SSD 6917: OAKDALE SOUTH – S.96(1A) APPLICATION TO CONCEPT PLAN TO INCLUE E2 / IN1 ZONE UPDATE ON LOT 3A

I write on behalf of Goodman, the applicant to SSD 6917 (Oakdale South Industrial Estate (OSE)), to lodge an application under S.96(1A) of the Environmental Planning and Assessment Act 1979 (the Act), for a modification involving minimal environmental impact.

This S.96(1A) application seeks to update the approved concept plans to replace a corner landscape, E2 zone in Lot 3A, OSE with hardstand, IN1 zone. This update corresponds with:

ELW - 001  
J  
21.06.2017

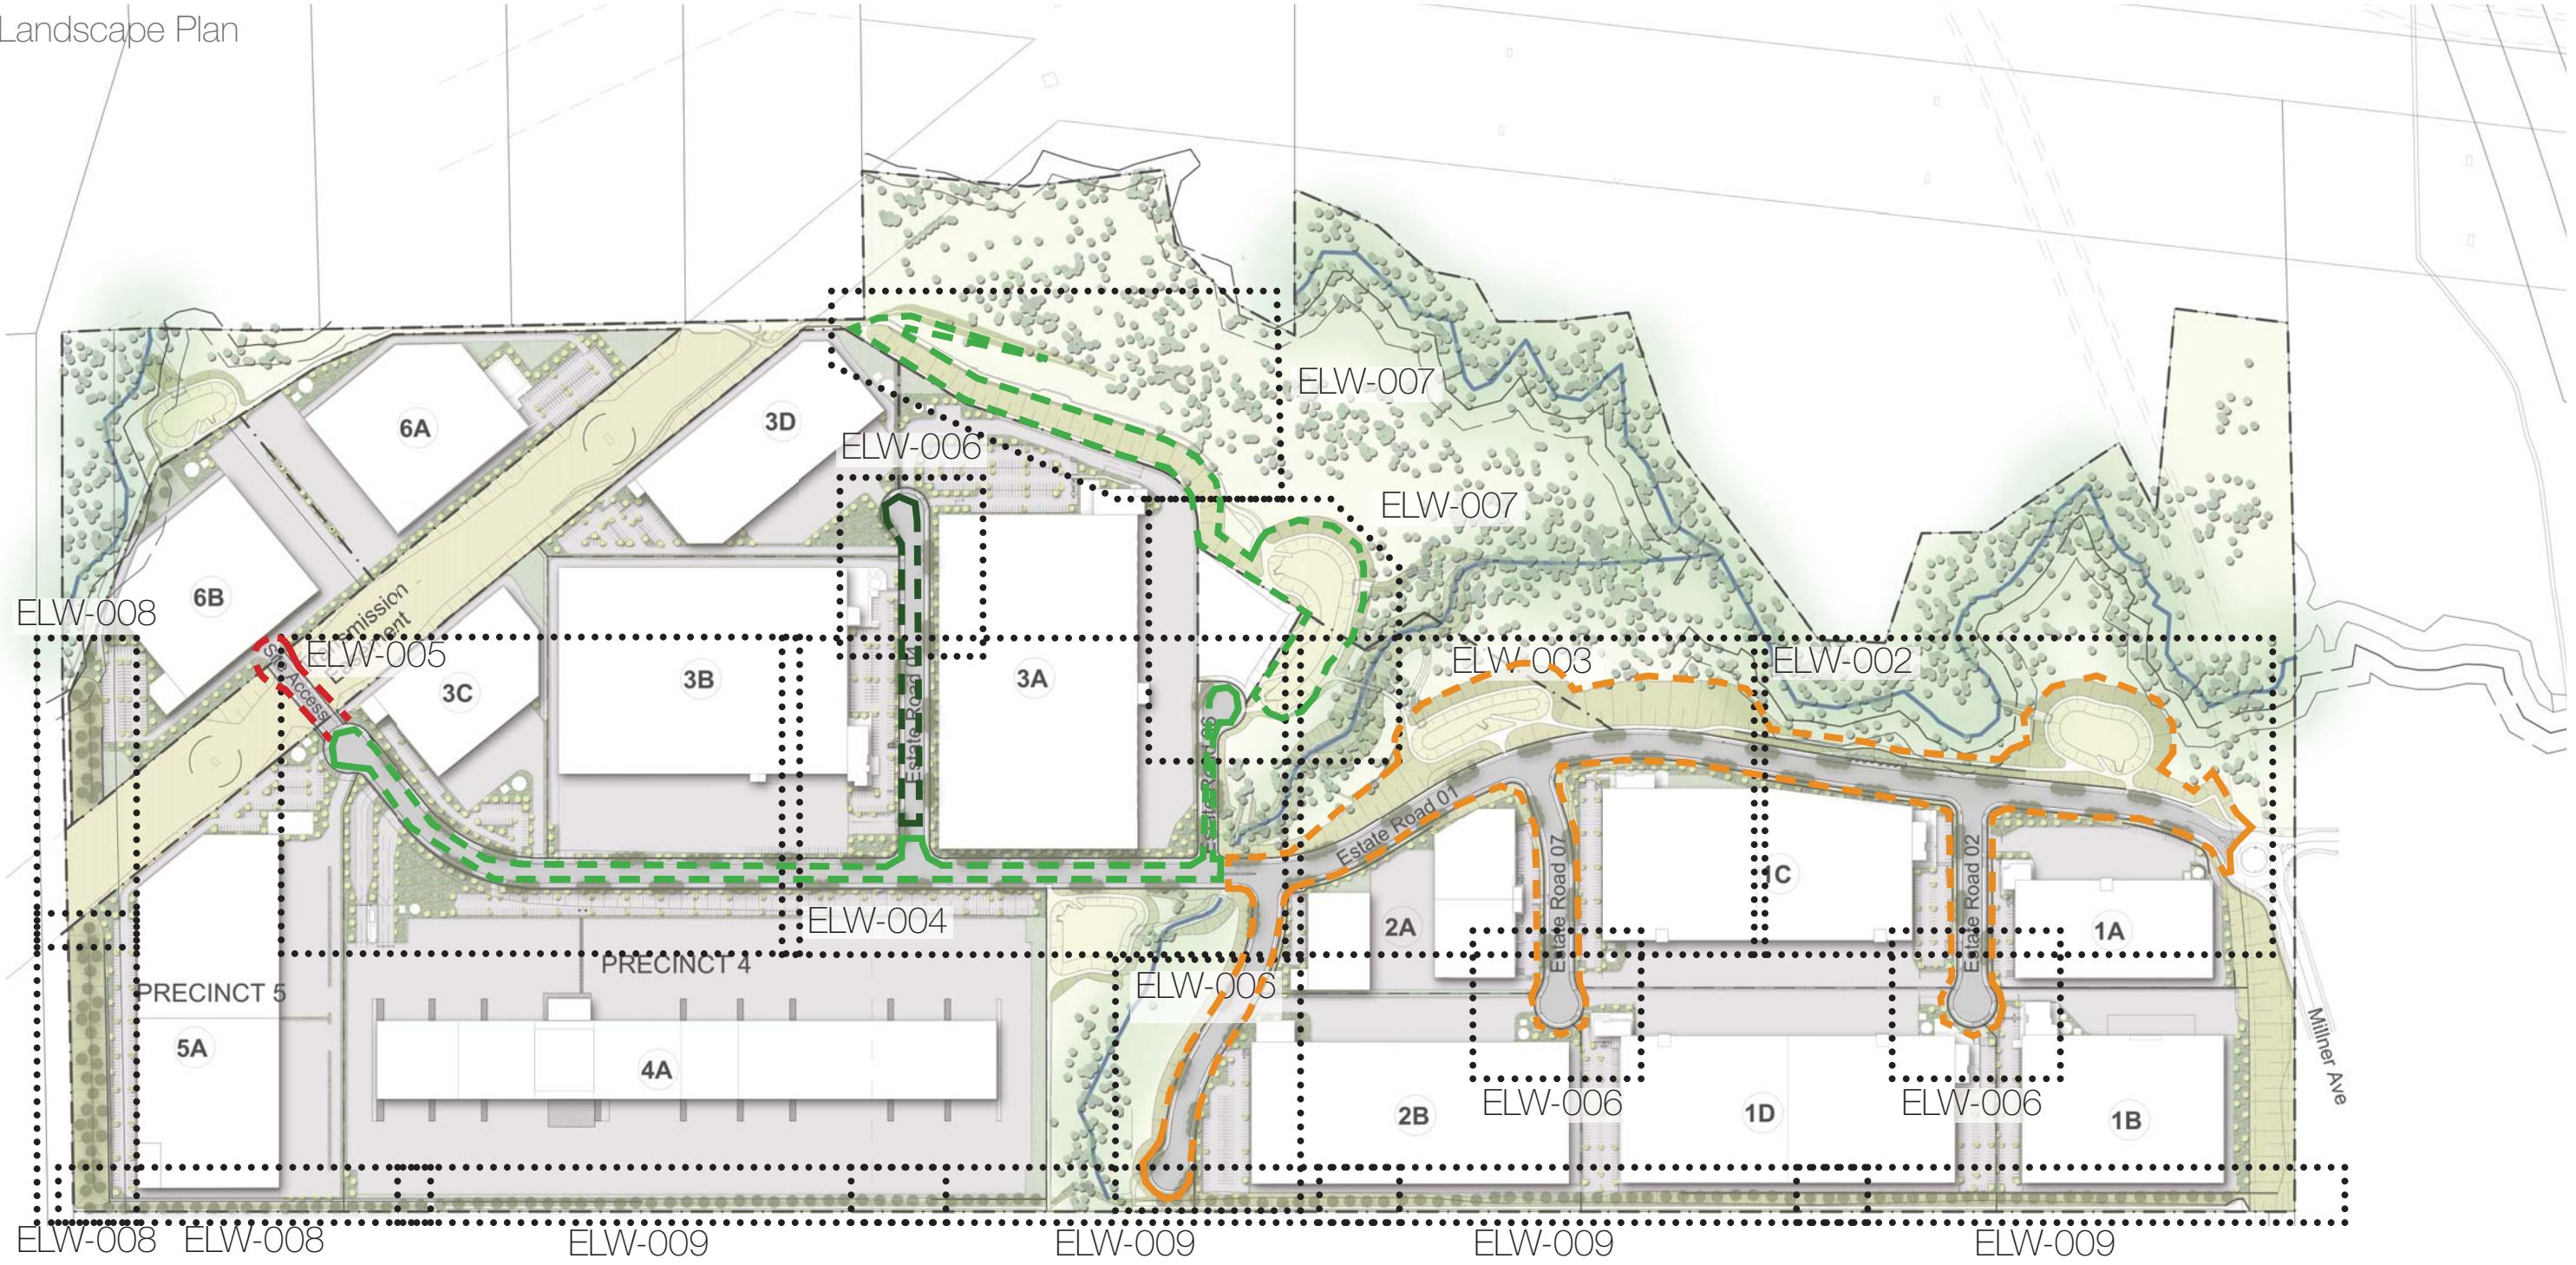
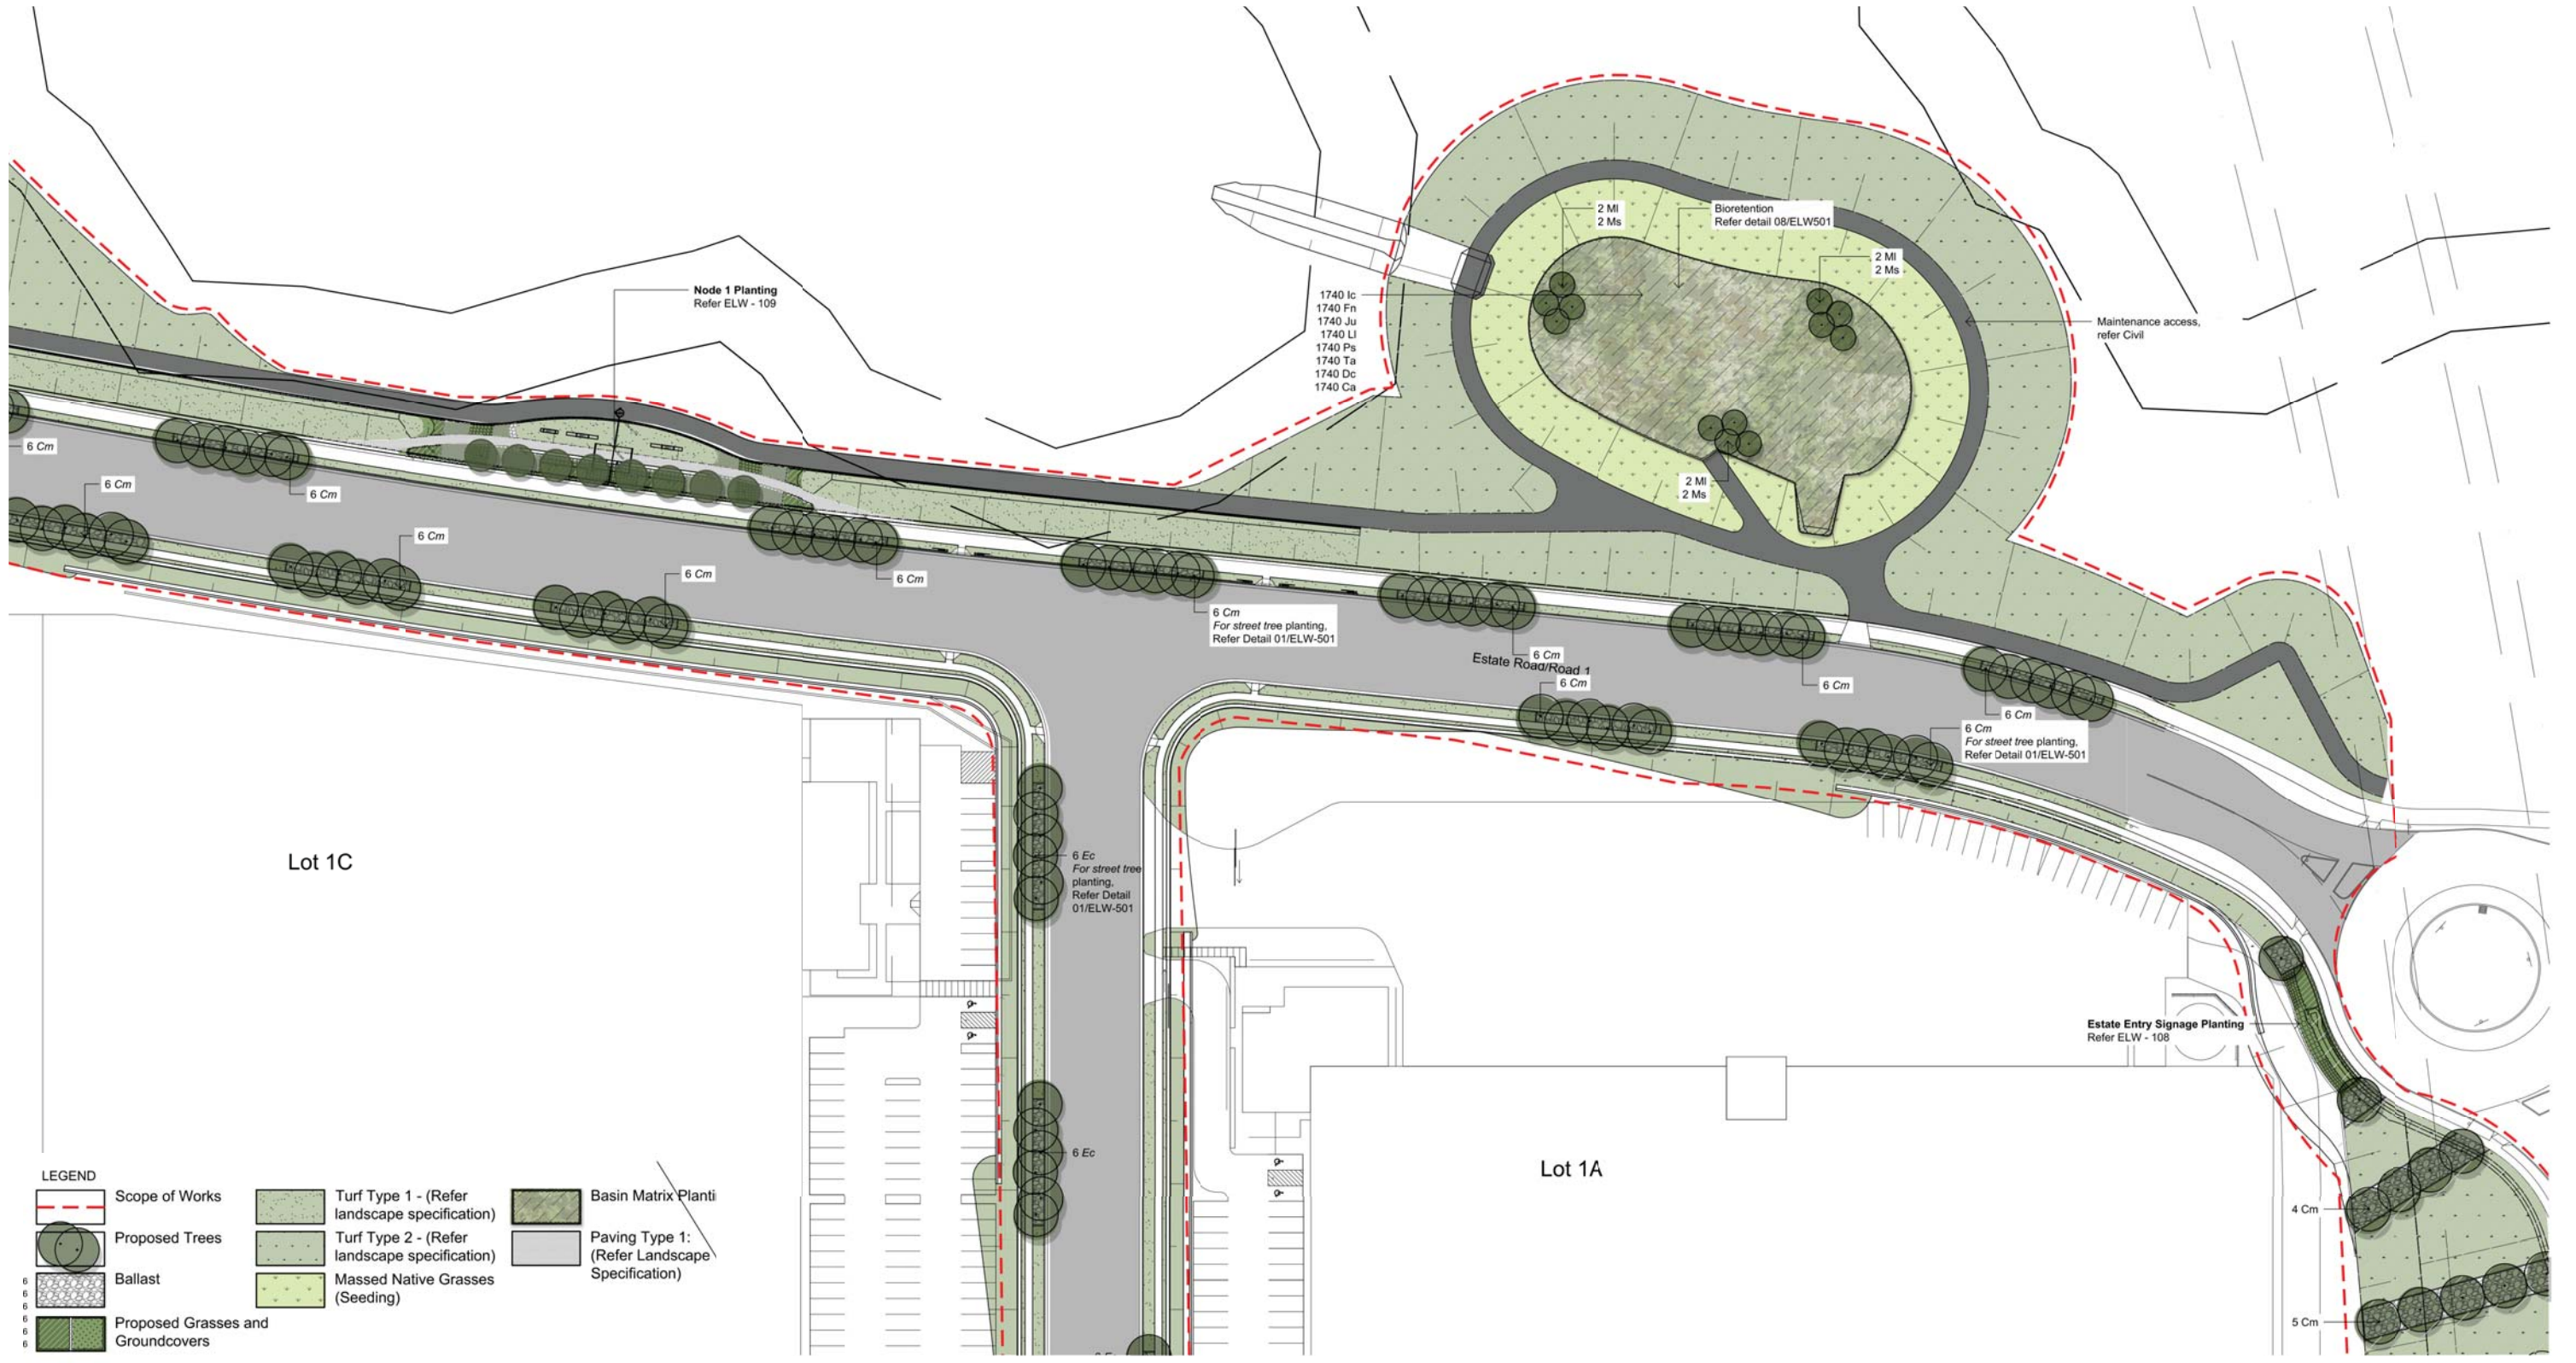
This application seeks to update relevant concept plans to remove E2 zone in the corner of the Lot 3A, replacing it with IN1 zoned land. This ensures consistency with that of the impending E2 / IN1 rezoning and SSD 7719 S.96(1A) plan update.

| Master Plan Drawings prepared by SBA Architects | | | |
|---|---------------------|--|--------------------------|
| ELW-001 | N O | Stage 1 Development Works - Landscape Plan | 27/09/2017 12/02/2018 |
